# **SSD 17\_8665 THE MERCANTILE HOTEL**

## **RESPONSE TO SUBMISSIONS**

2 APRIL 2019  
SA6771  
FINAL  
PREPARED FOR HBMS NSW PTY LTD

Drawing No.
SSDA 601

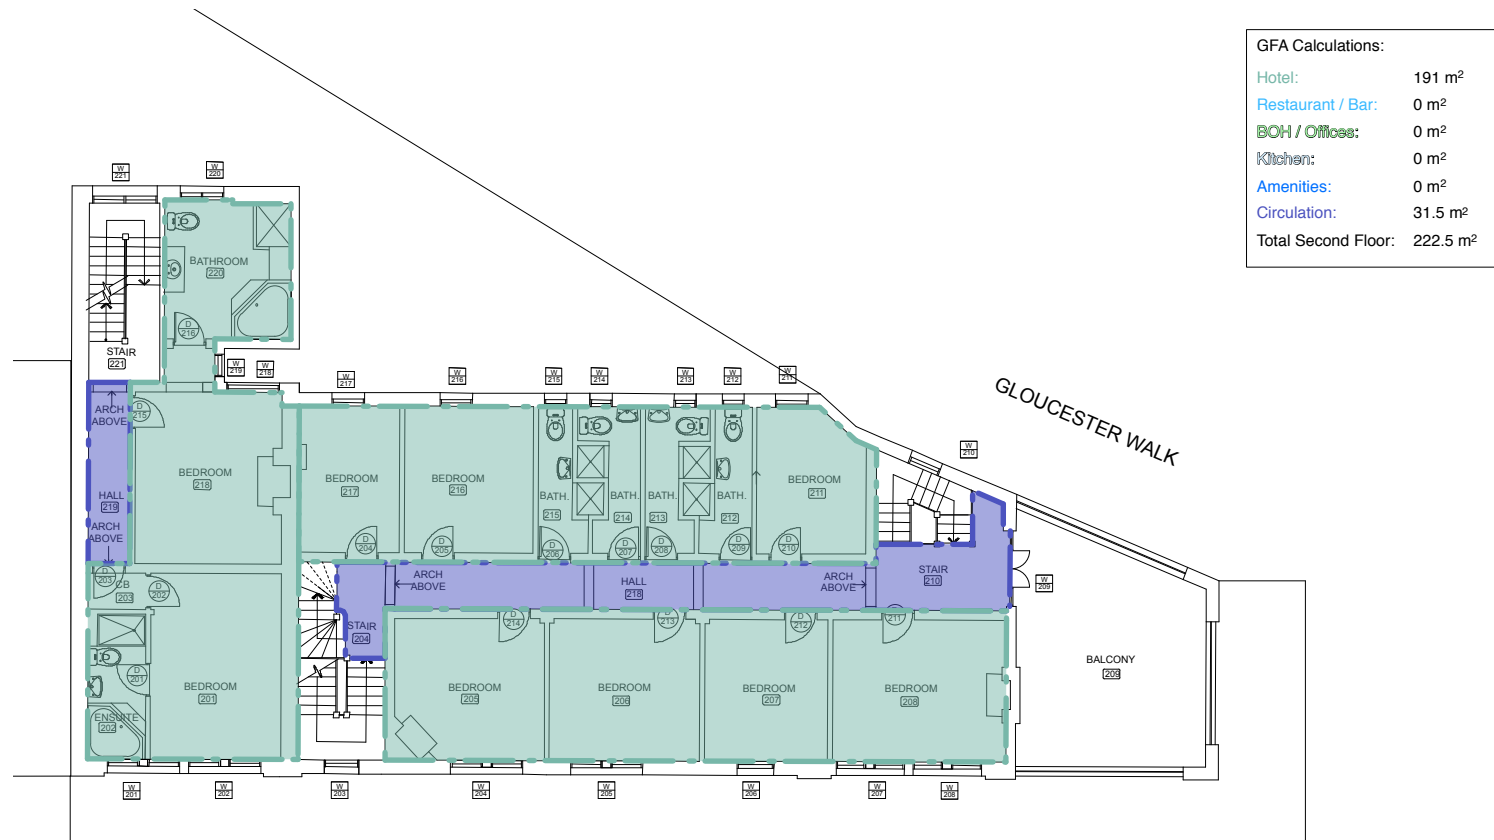
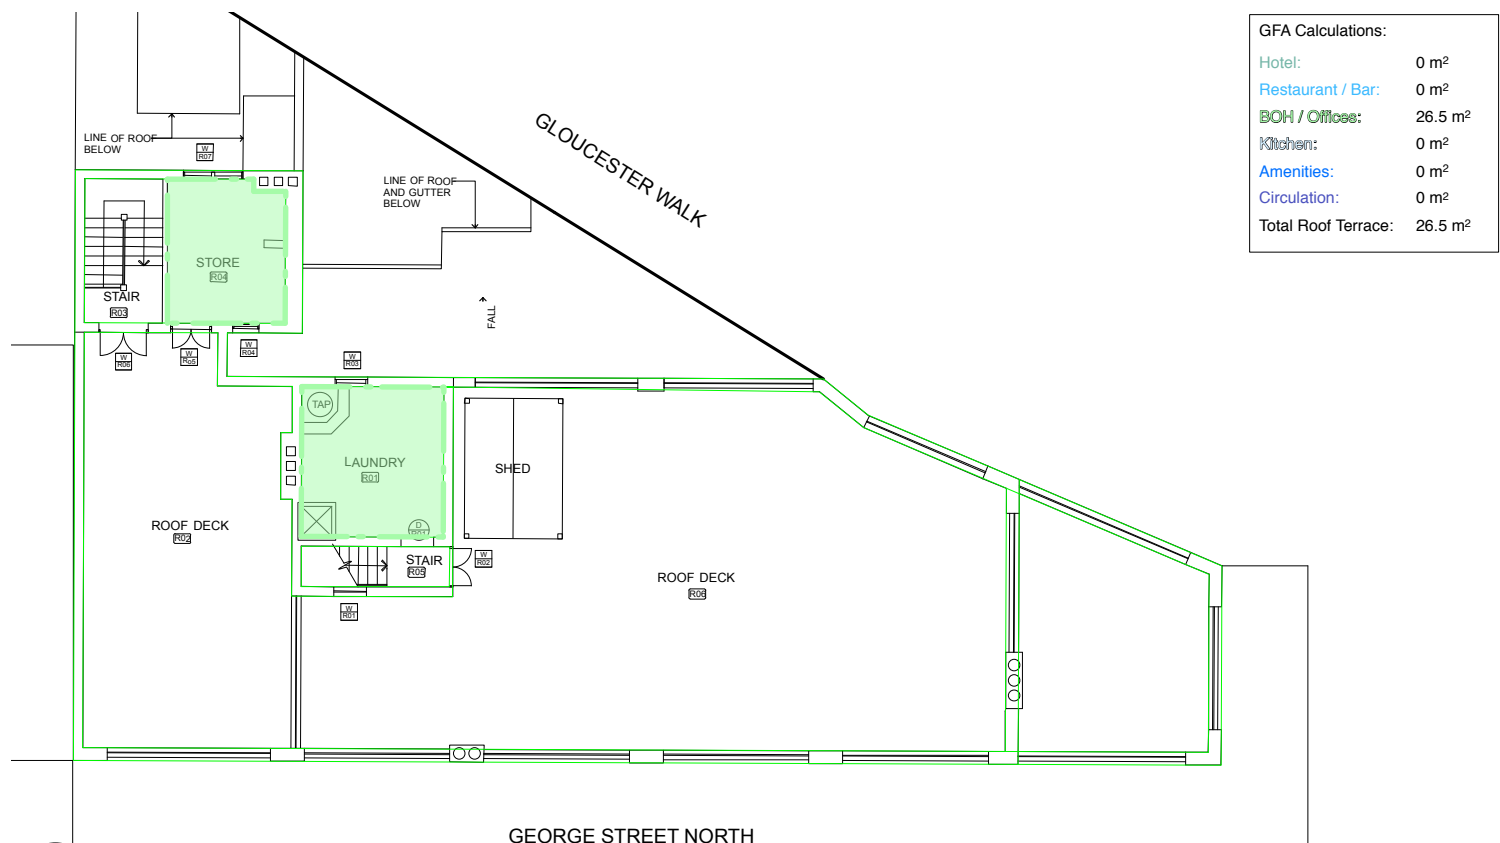
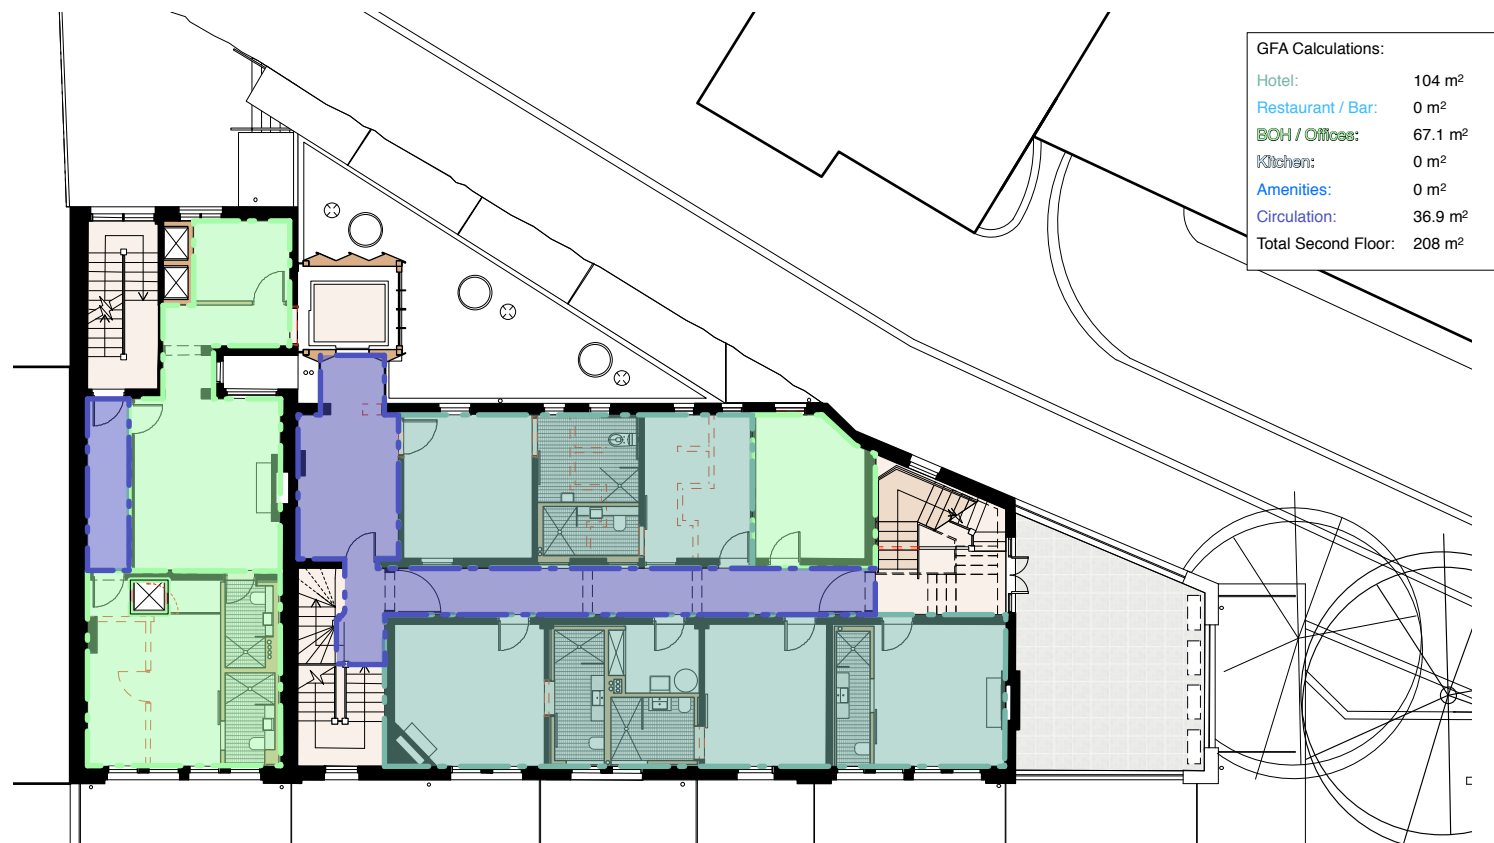
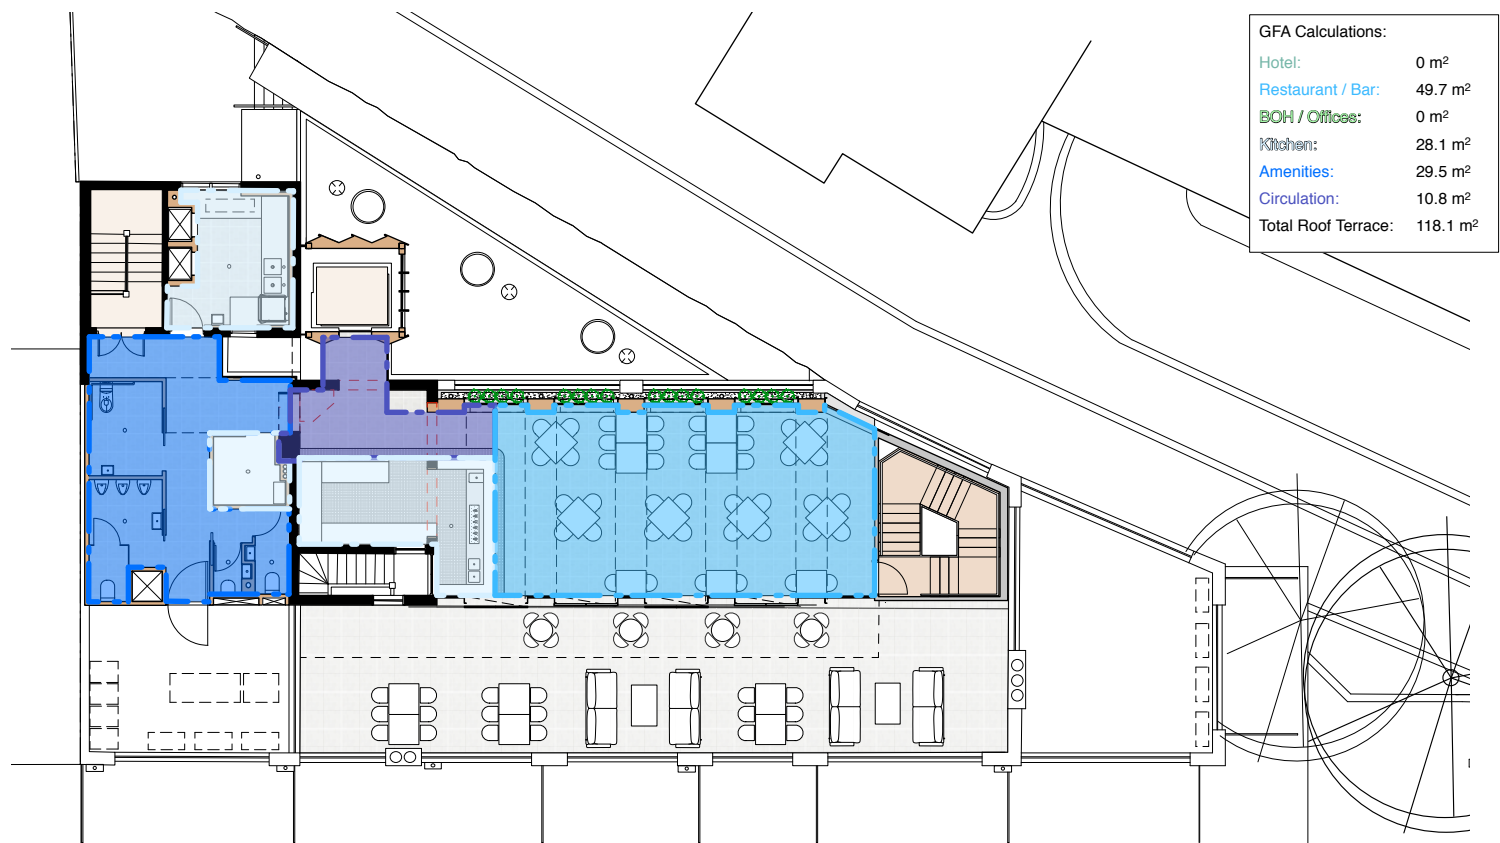
5. Use	Provide a clear schedule of current and additional GFA, with a breakdown by use	<ul style="list-style-type: none"> <li>Welsh + Major Architects have prepared GFA plans as part of this RtS.</li> </ul>	Appendix A
